NOTICE TO CONTRACTOR
 All construction must comply with current NC Building Codes and is subject to field inspection and verification.

APPROVED
 Limited building only review
 Permit holder responsible for full compliance with the code

10/12/2021

**BONUS ROOM PLAN**  
SCALE: 1" = 1/4"

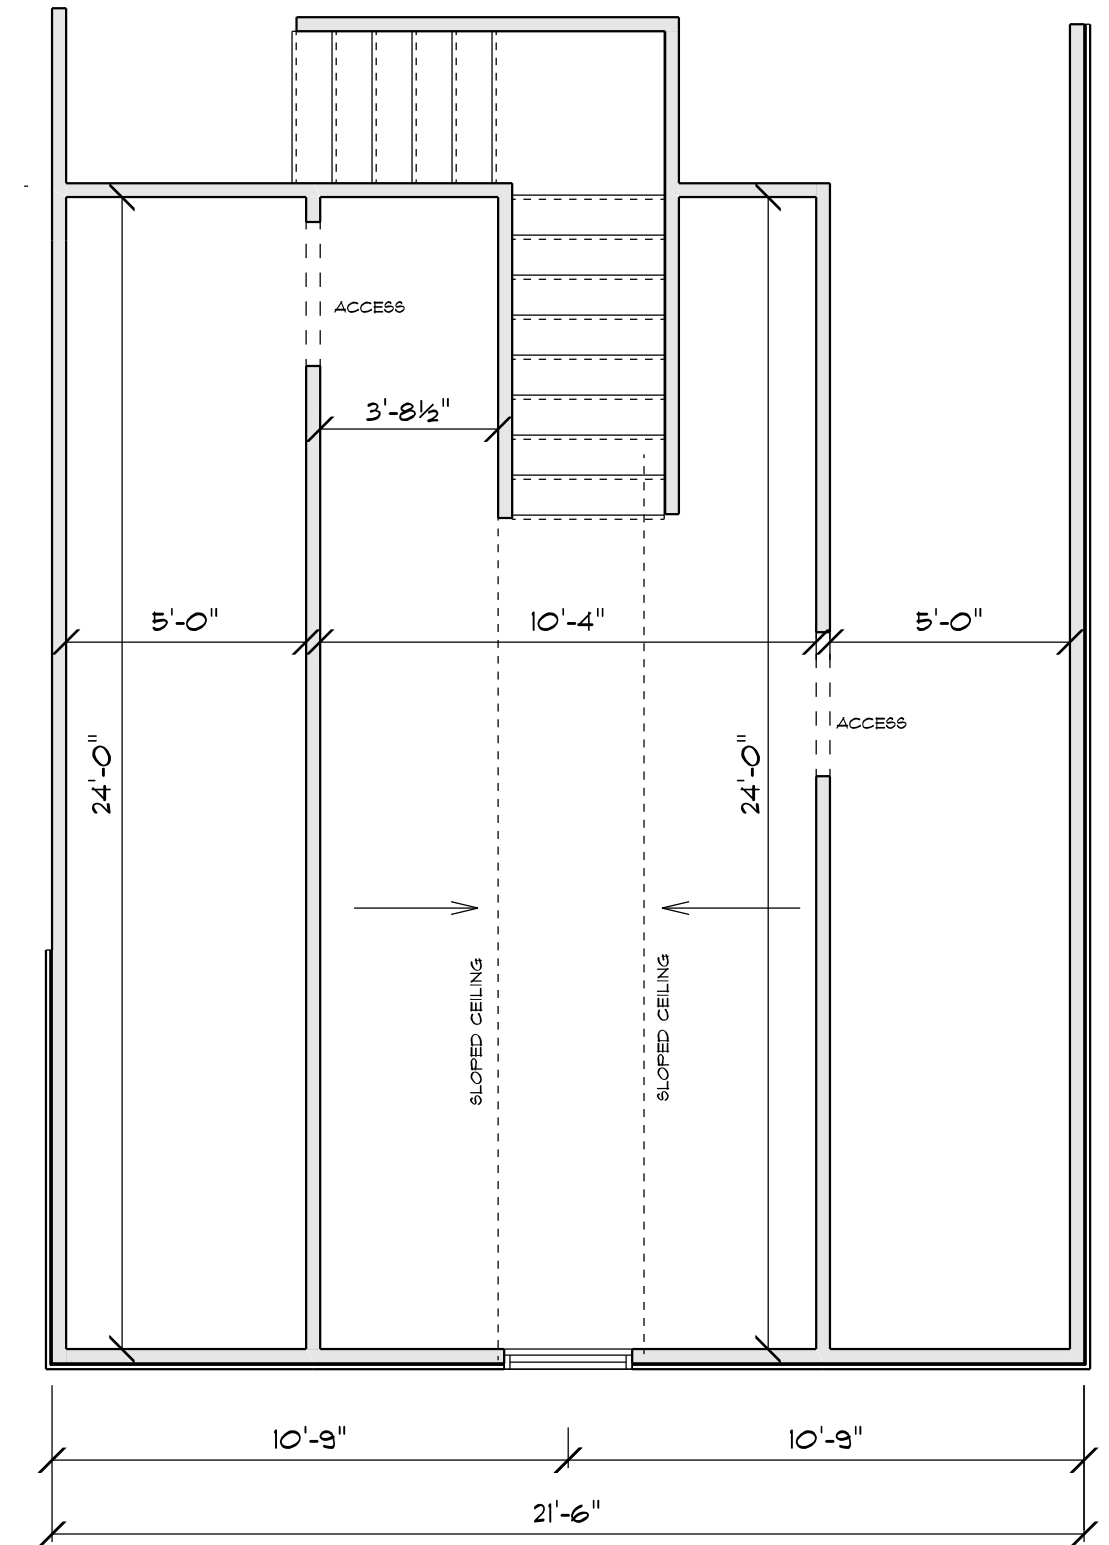
Window must meet egress size
